Our reference: ECM 8375601
Contact: Gavin Cherry
Telephone: 4732 8125

12 October 2018

Notice of Exhibition – Nepean Hospital and Integrated Ambulatory Services Redevelopment (Stage 1) (SSD 8766) at 35 – 65 Derby Street, Kingswood

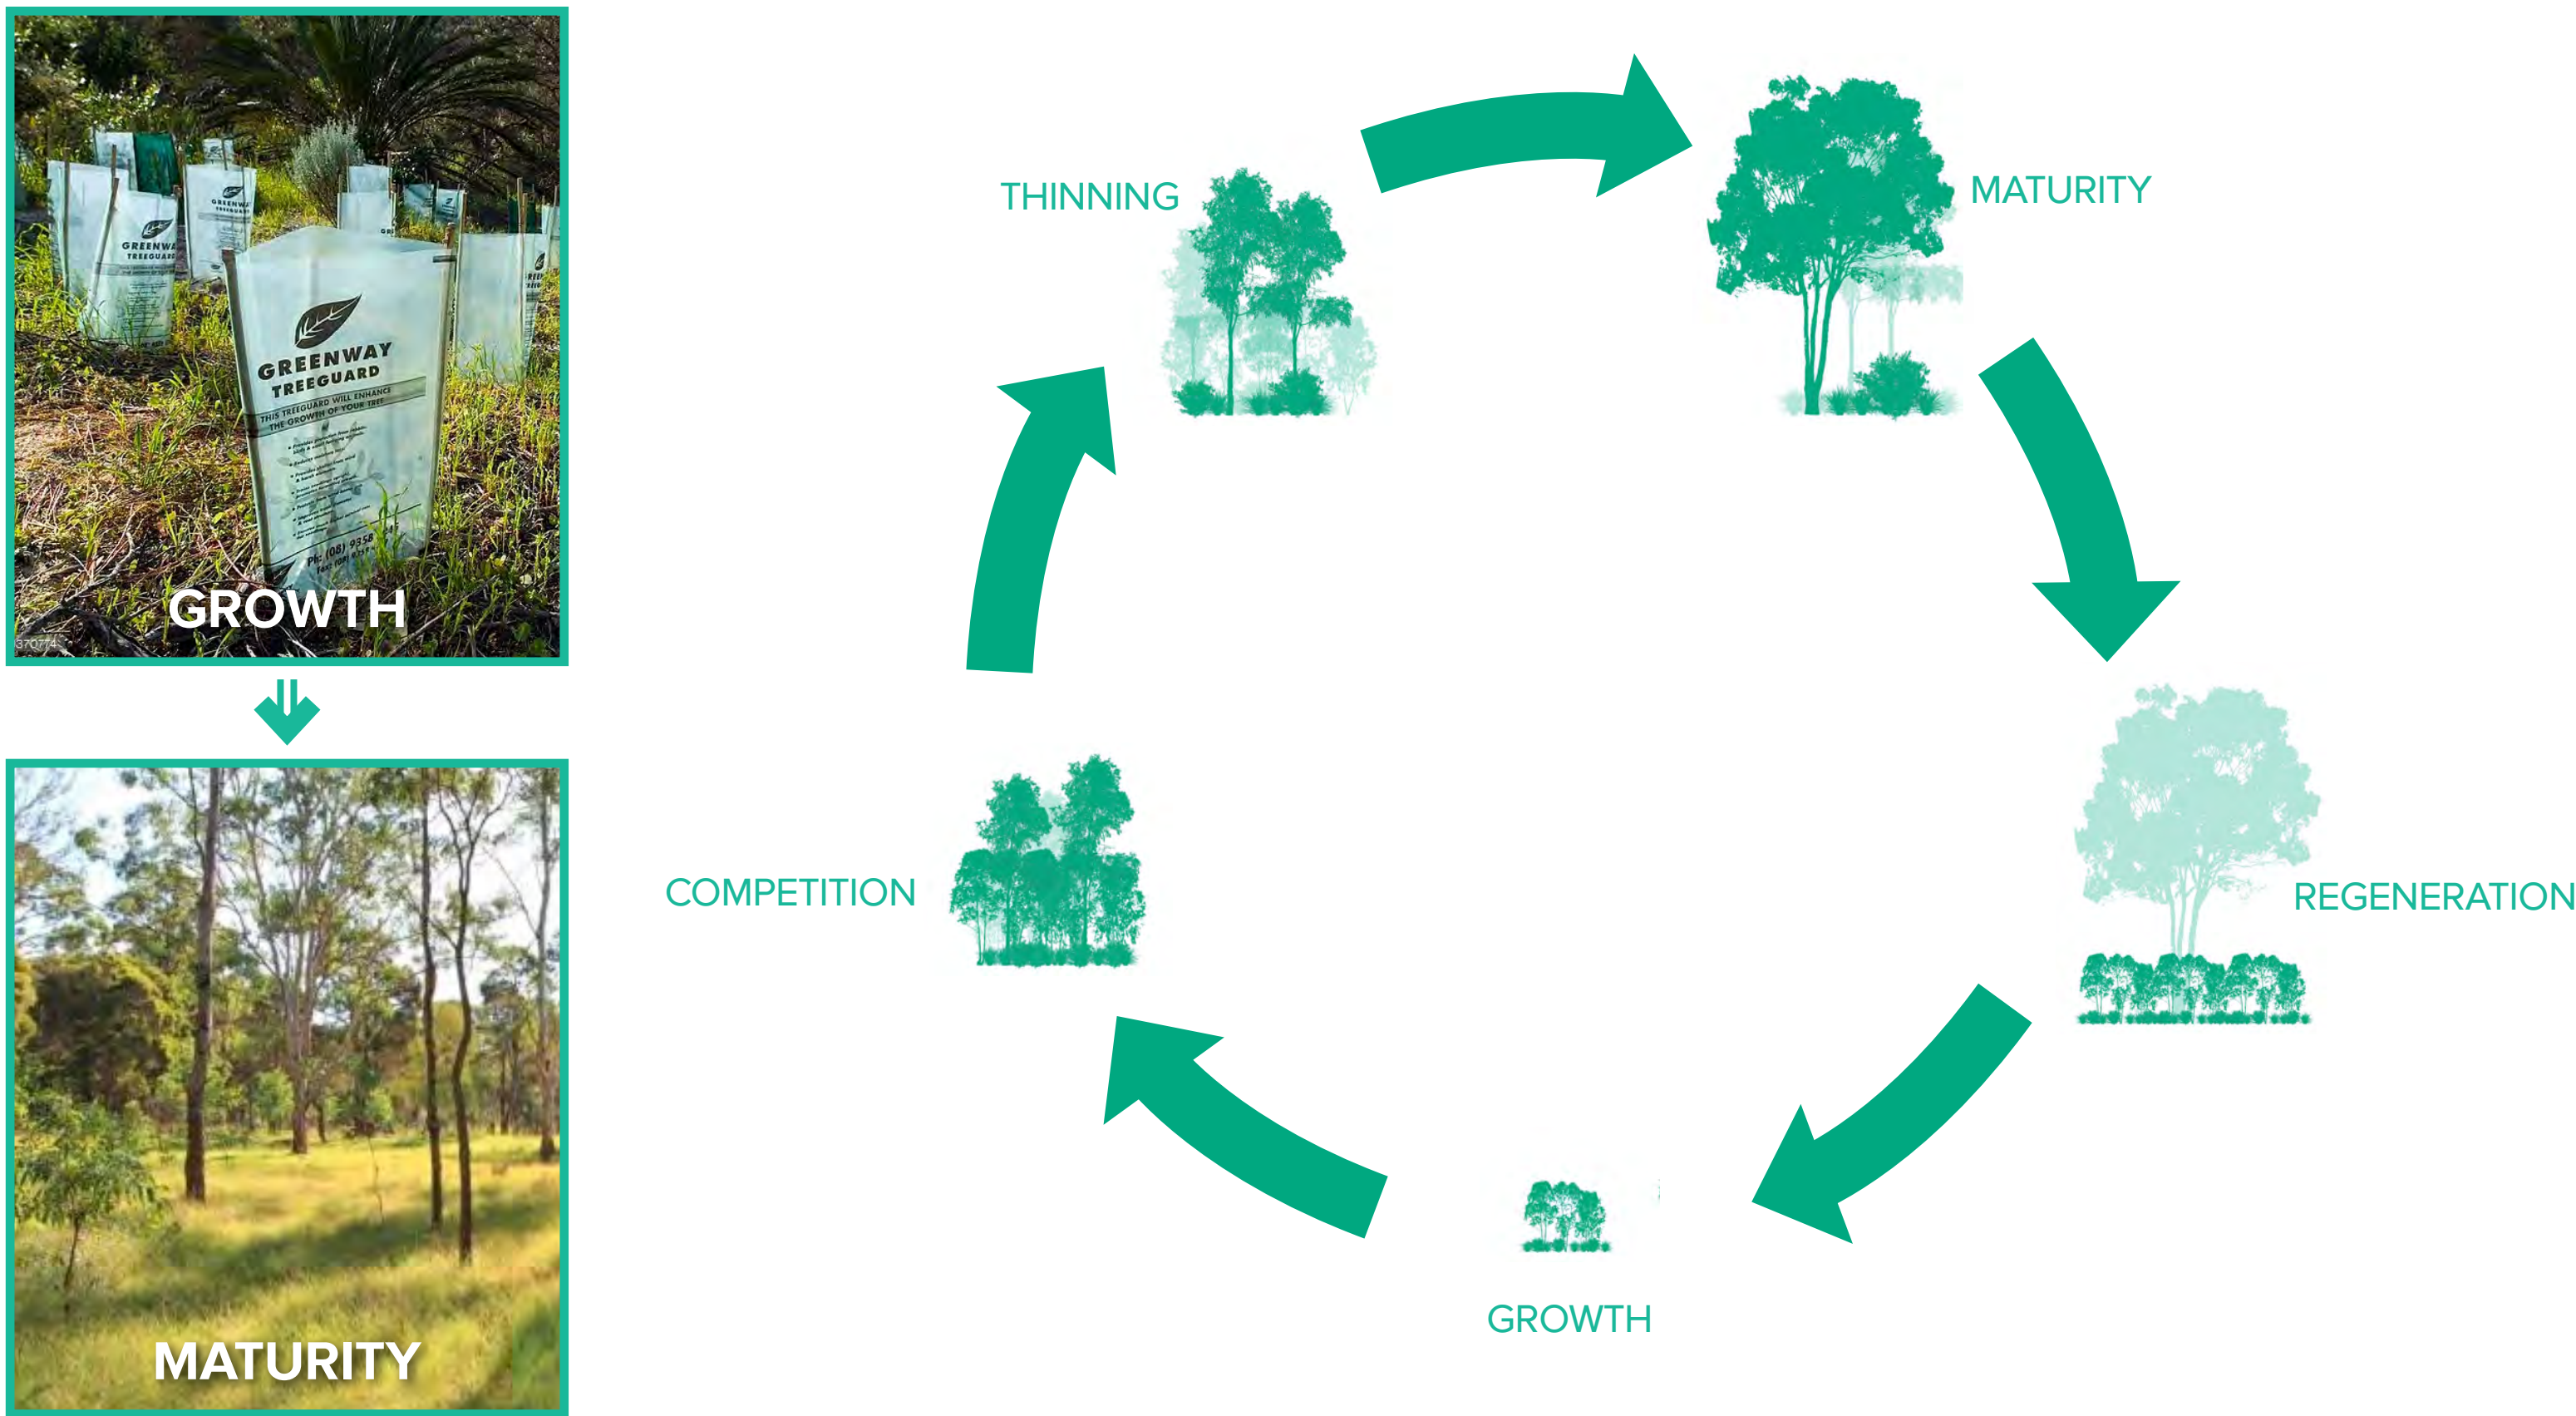
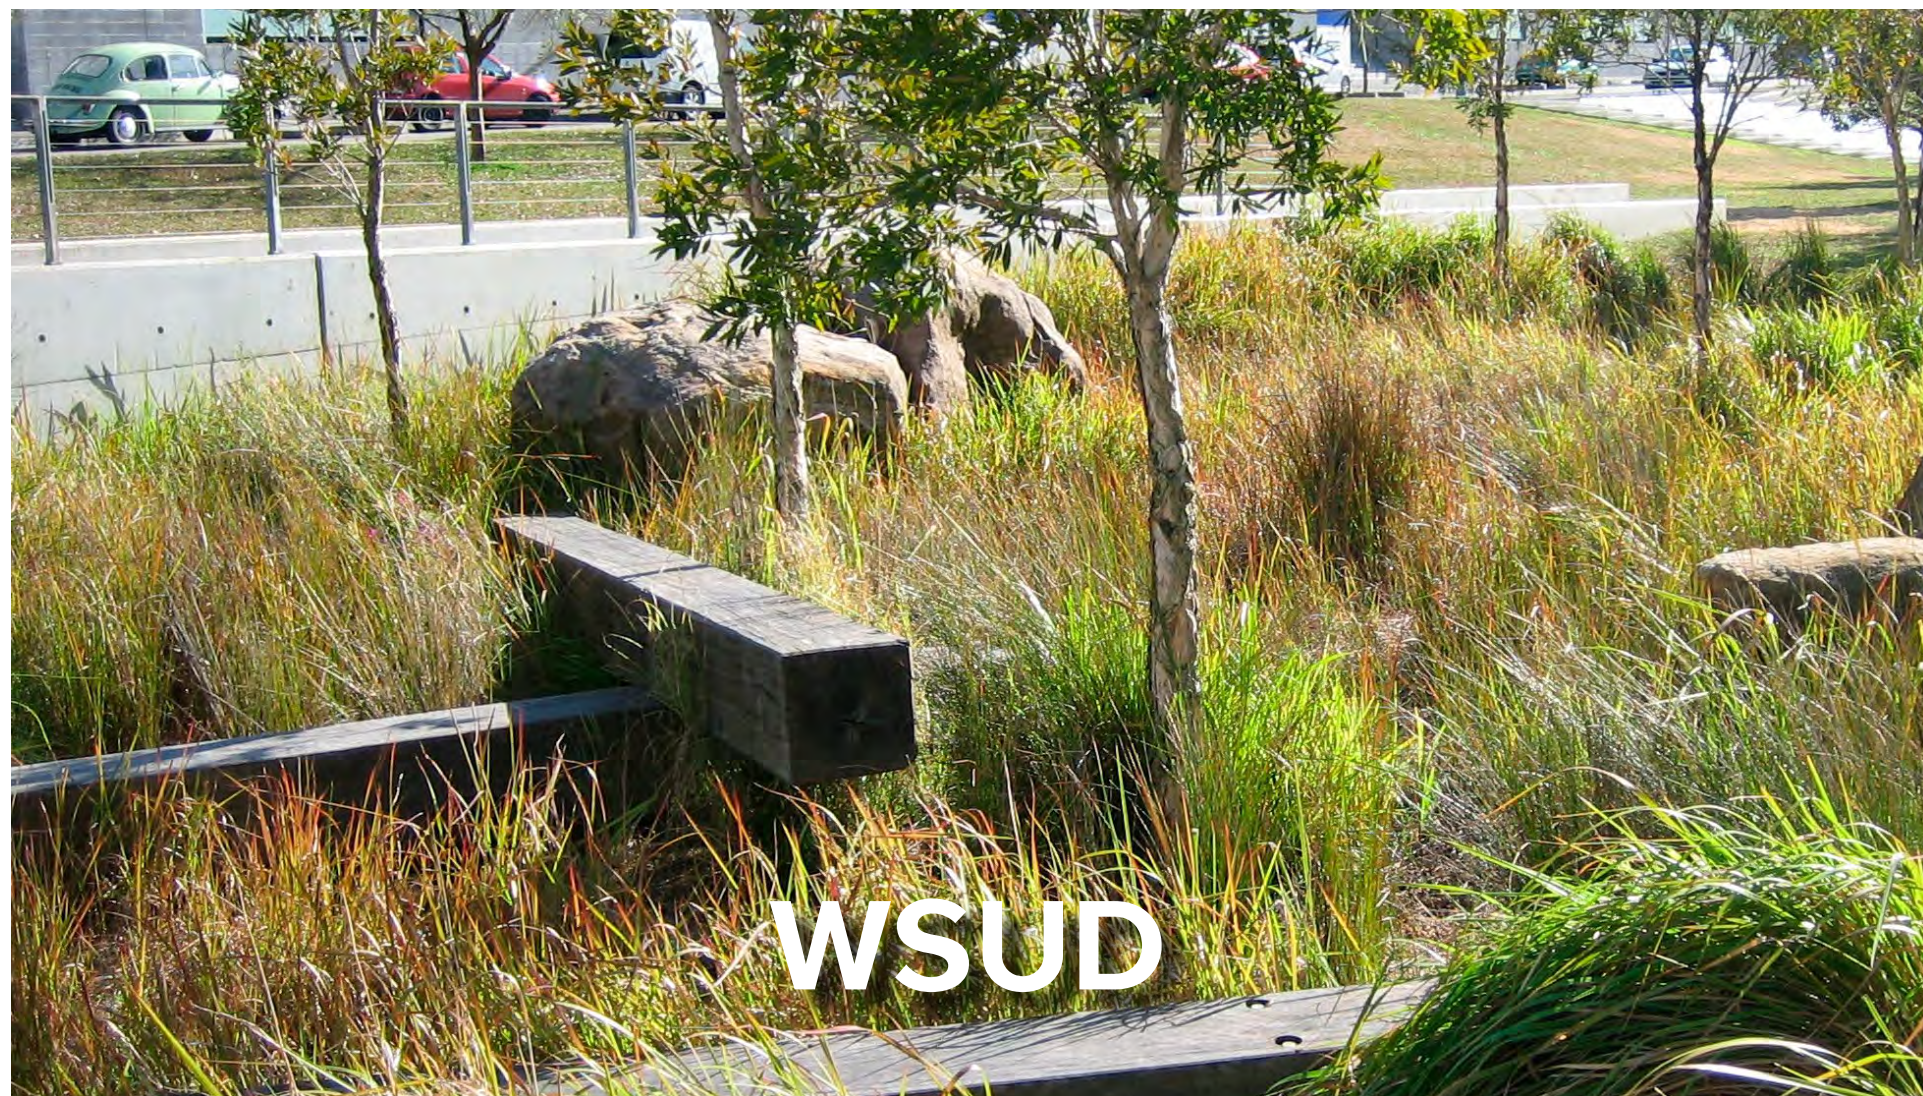
The proposed landscape vision for the site is predicated on a Blue Mountains character theme which is inappropriate given the availability of limited landscaped space and the urbanised nature of the development.

The site is not within the Blue Mountains and is located within a health and education precinct which will be surrounded by multi storey residential, commercial and medical developments rather than an expansive bushland setting.

The landscape theme and planting design should be revised to reflect the urban landscape setting in which the site sits, with suitable spatial separation between large canopy trees and plant species and densities suitable for this space.
